DECISION DELEGATED TO HEAD OF PLANNING

Application No: H09-0192-23 **Applicant:** Mr A Clues
Proposal: Alterations and extension
Location: Landmere Cottage Main Road Holbeach Drove
Terminal Date: 9th May 2023

SITE PLAN
1:250

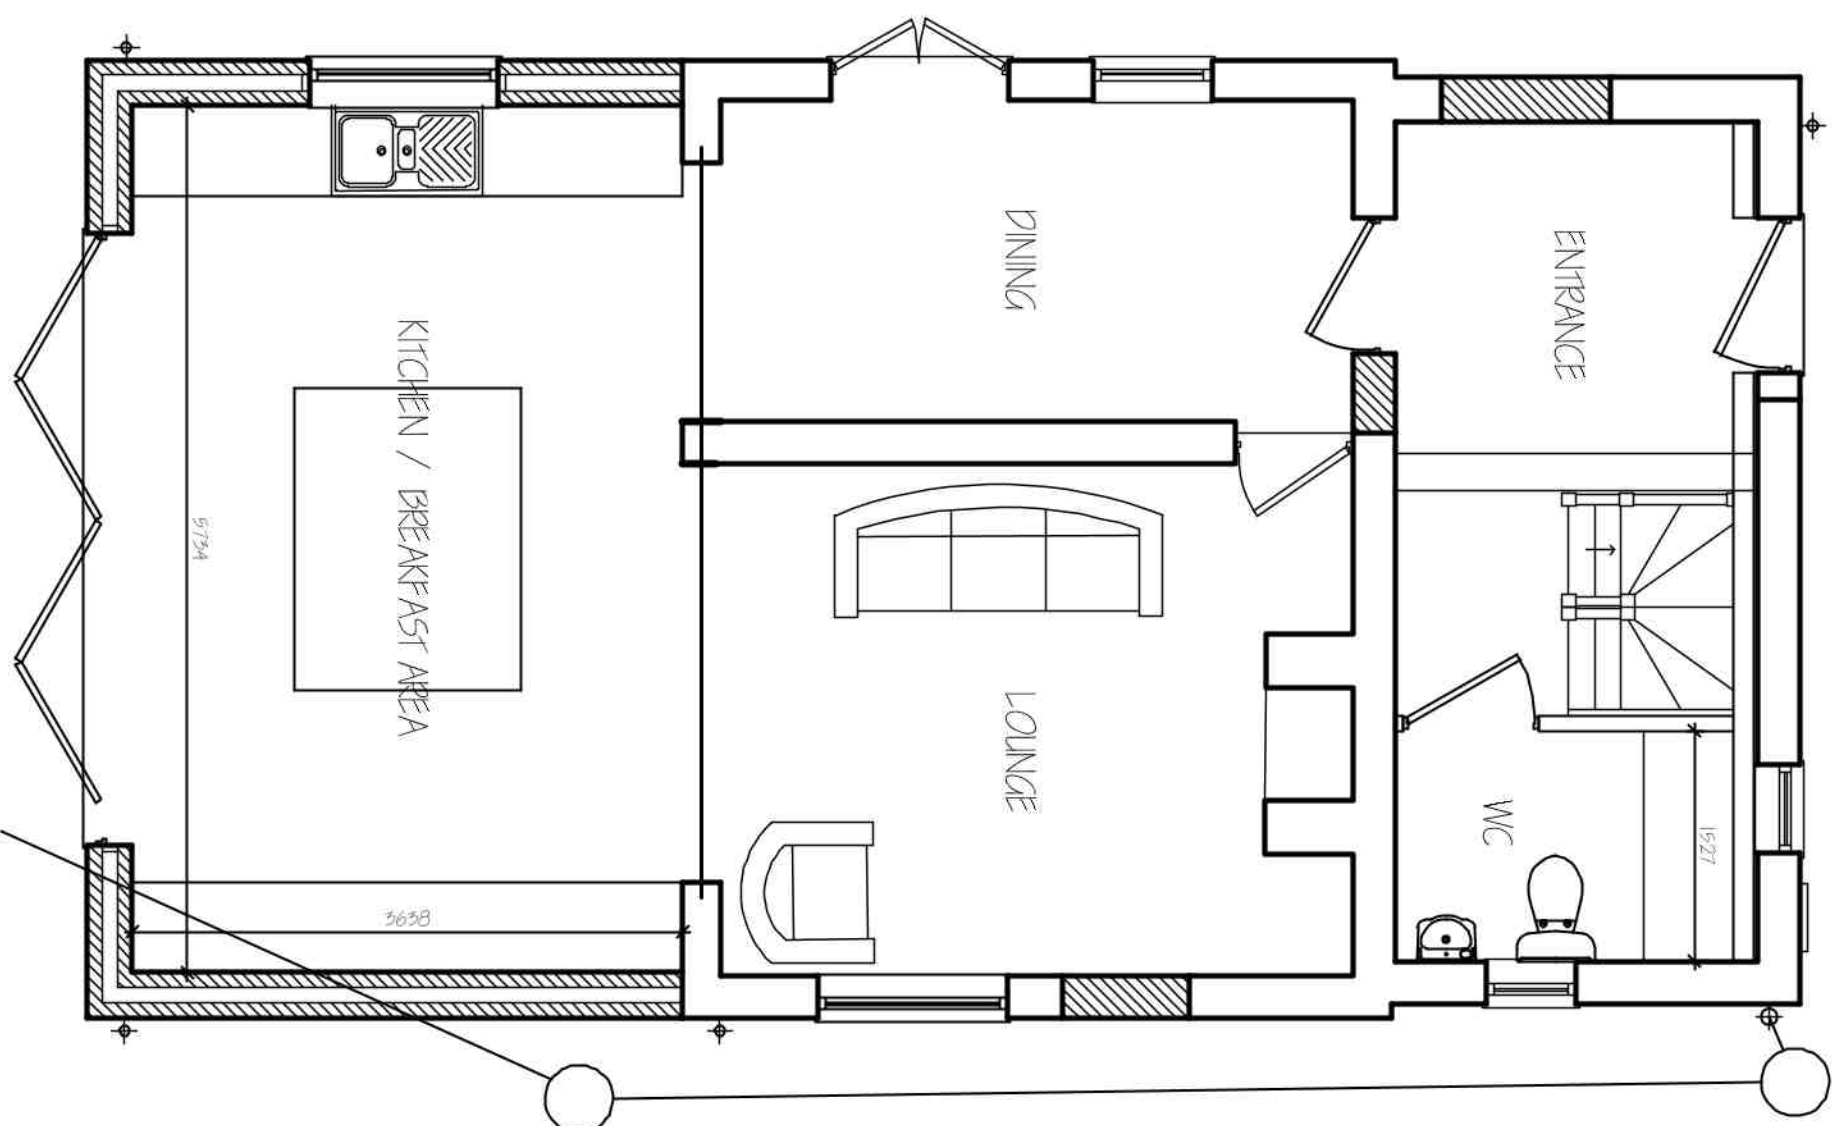
"We are pleased to see that the extension has now been moved to 9 metres from the brink of the watercourse. The applicant has also approached the Board to apply for consent for the fencing and gates within 9 metres of the Board maintained watercourse, which is currently being processed under reference: 23_08220_C. As the revised site plan (4108-22, 02D, April 2023) now shows no permanent structures within 9m, and a consent application is being processed for the fence, we no longer object to this application."

"Please be aware, however, that the updated site plan provided shows that the fence is located 300-400 mm away from the brink. The Board is unlikely to grant consent for fencing any closer than 1 metre from the nearest brink of the watercourse, which has already been discussed with the applicant. As such, this distance will need to be amended on the plans for any eventual consent issued by the Board. We will leave it to the LPA to decide if this will also need changing as part of the planning application."

NOTE - Following receipt of these comments the agent has now removed the proposed fence from the eastern boundary. A relaxation application to the Internal Drainage Board is no longer required.
